From: Skye Shanahan <Skye.Shanahan@transgrid.com.au>
Sent: Friday, 15 July 2016 5:12 PM
To: Thomas Piovesan
Cc: Kate MacDonald
Subject: RE: Oakdale South - SSD 6917
Attachments: TG Easement Guidelines for Third Party Development (V10).pdf

Re: Oakdale South Industrial Estate (SSD 6917) – Referral of Applicant's Response to Submissions

SSD6917 - Oakdale South Industrial Estate, TL: Syd Sth - Syd West No.1 330kV (Fdr 30 Str 10-13 & Fdr 14 Str 110-111)	
Property of Transgrid. No warranty is given that information shown is complete or accurate.		PRODUCED FROM TAMIS	Scale: 1:15000
18/11/2015 15:14:49 Created by: P86665		A4

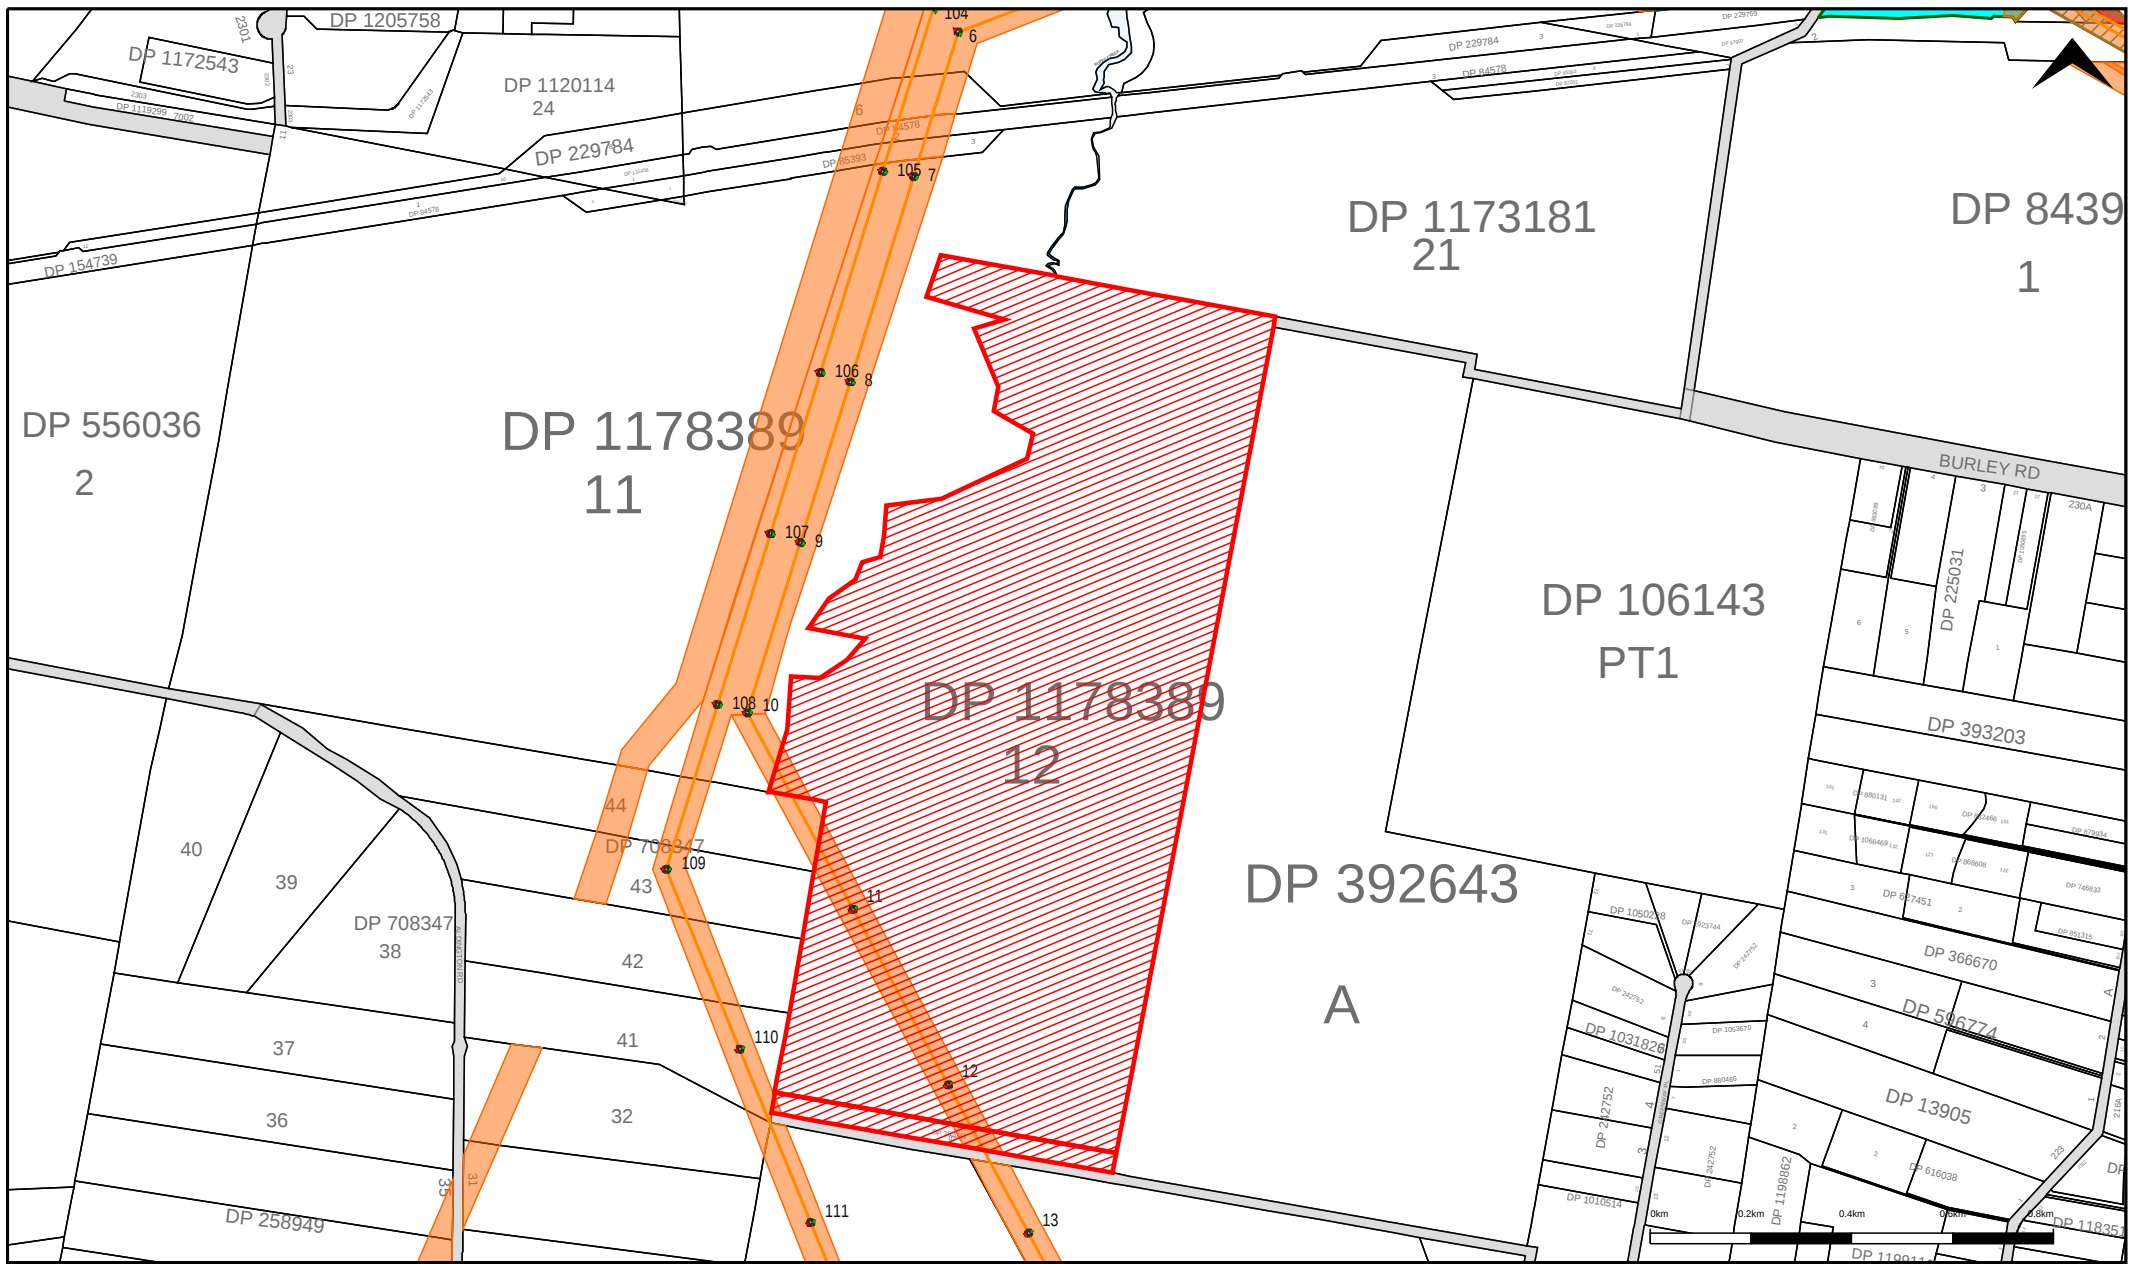
- Referencing to the drainage and potential flood issues within our easement corridor, each of these aspects will be individually assessed through the formal Statutory Notification process (either with the Department Of Planning and/or local Government Council). Detailed plans in PDF format will need to be present to TransGrid outlining how the developer will preserve our easement corridor from being a permanent damp and un-accessible area for our large mobile plant and equipment to maintain the transmission line network. TransGrid needs to ensure all water levels are directed away from the easement, and appropriate measures such as drains on either side of the easement are implemented.

- TransGrid's access to the transmission lines, stanchions and easement must be maintained at all times across the full width and length for ongoing maintenance purposes. Please note our heavy vehicle plant and equipment can weigh in excess of 40 tonnes. All disturbance to the ground will need to bear this weight.

- Any proposed encroachment of TransGrid's easement will need to be thoroughly reviewed and assessed by our Engineers, or it will be considered as a prohibitive encroachment. This will include checking ground clearances for any road undercrossings, basins and landscaping.
